STATE OF WASHINGTON
DEPARTMENT OF ECOLOGY

April 20, 2022

Re: RU 22-00002

Thank you for providing the Department of Ecology (Ecology) an opportunity to review and comment on the proposed wetland buffer reduction for the East Peak Development, LLC Reasonable Use Variance request.

**WETLAND BUFFER
ENHANCEMENT PLAN**

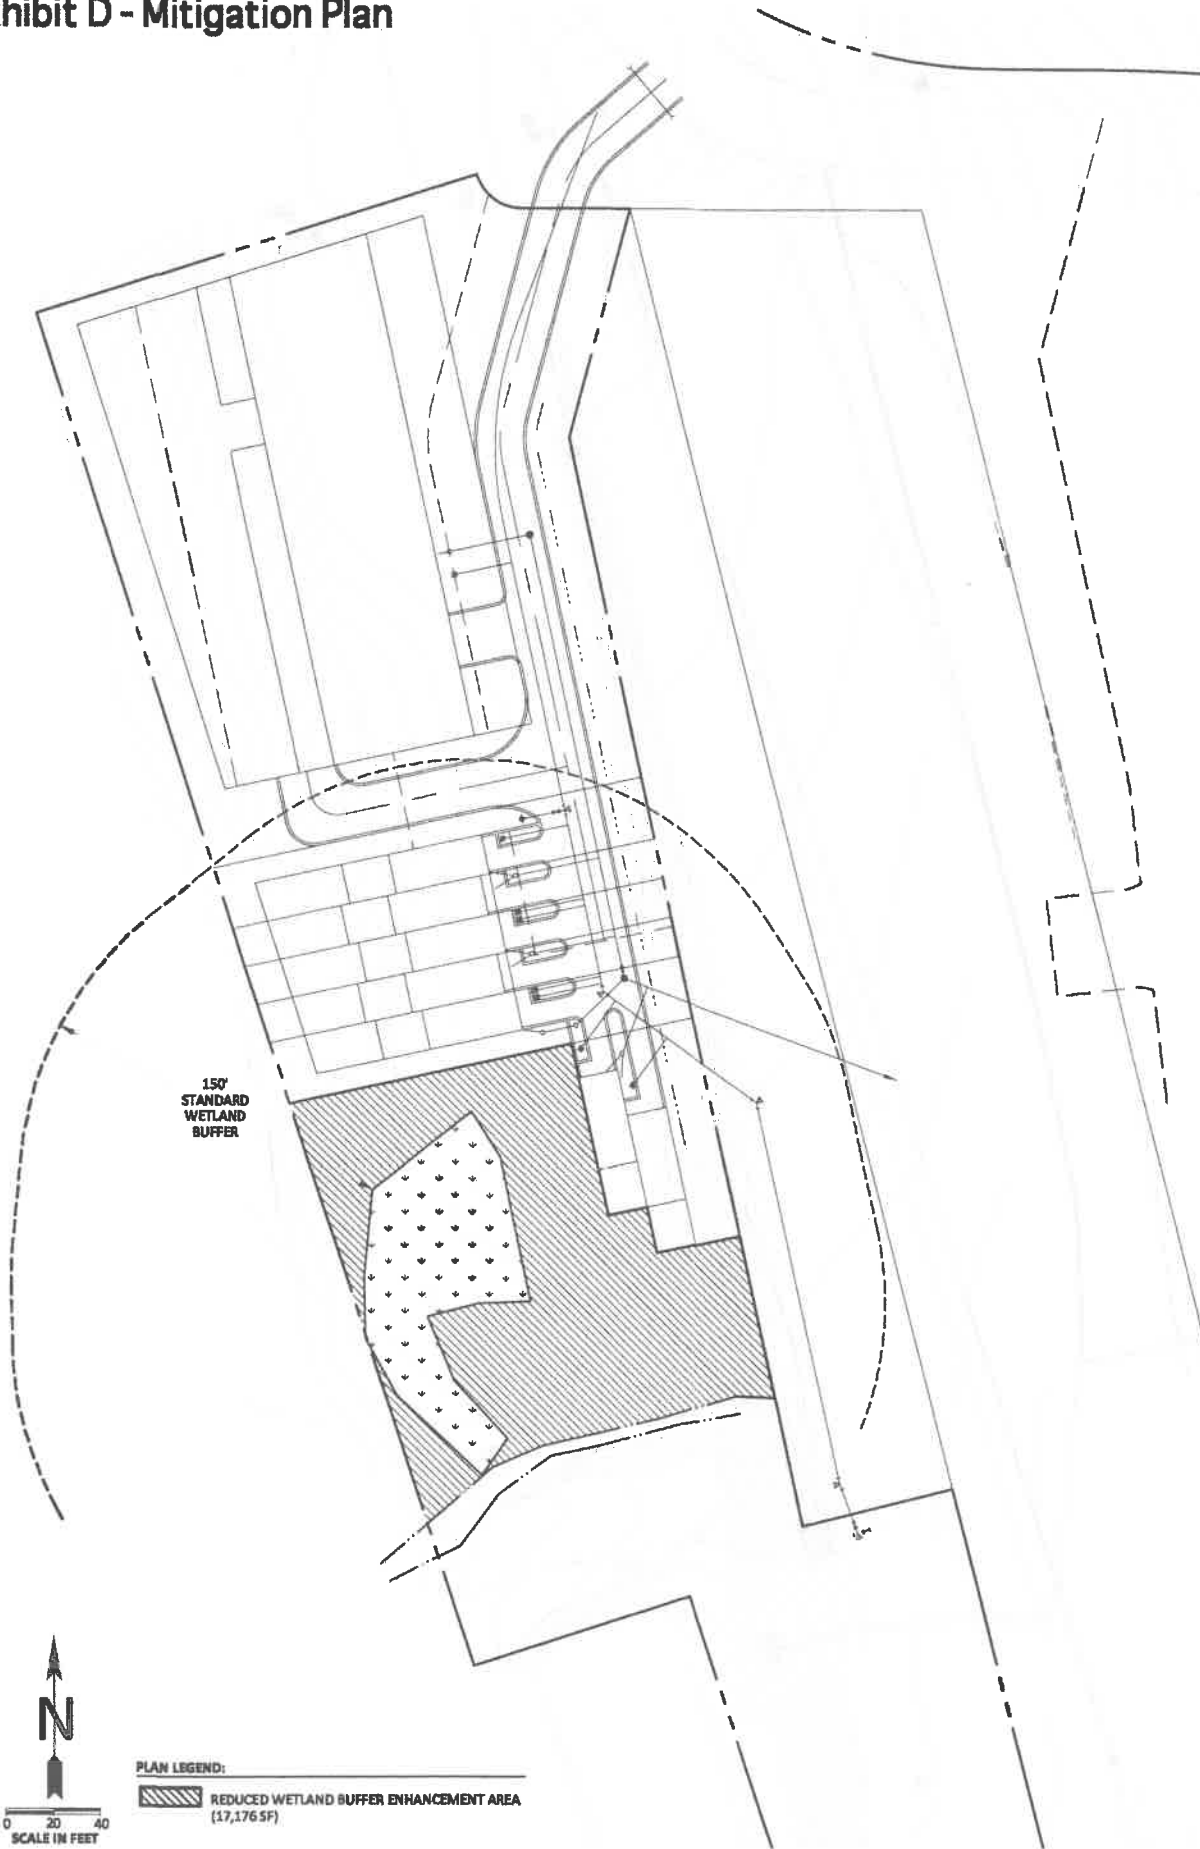
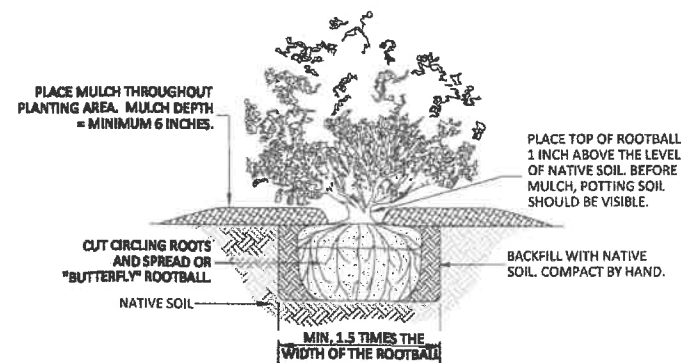
- Buffer reductions without the use of buffer averaging, should be mitigated for at a 1 impact area: 1 replacement area ratio. Ecology guidance documents were written with the assumption that there is an existing functional buffer in place. If there is not one (it is lawn grass, sparsely vegetated, or vegetated by invasive species) the buffer is to be appropriately planted with native vegetation prior to the change in landuse. Therefore any buffer planting is expected to have already taken place and is not acceptable to be used as a form of mitigation. The buffer should be planted and mitigation for impacts provided per area of impact.

- It is unclear what width the buffer is being reduced to.
 - The planting plan proposes the use of three tree species. It should include shrubs and an herbaceous layer as well for added structure, screening, and filtering purposes.

- Monitoring of planted woody material should be for 10 years with the potential for early release if meeting performance standards.
- Goals and Objectives of the overall mitigation monitoring plan should be included. It needs to be expanded on beyond that of Year 2.
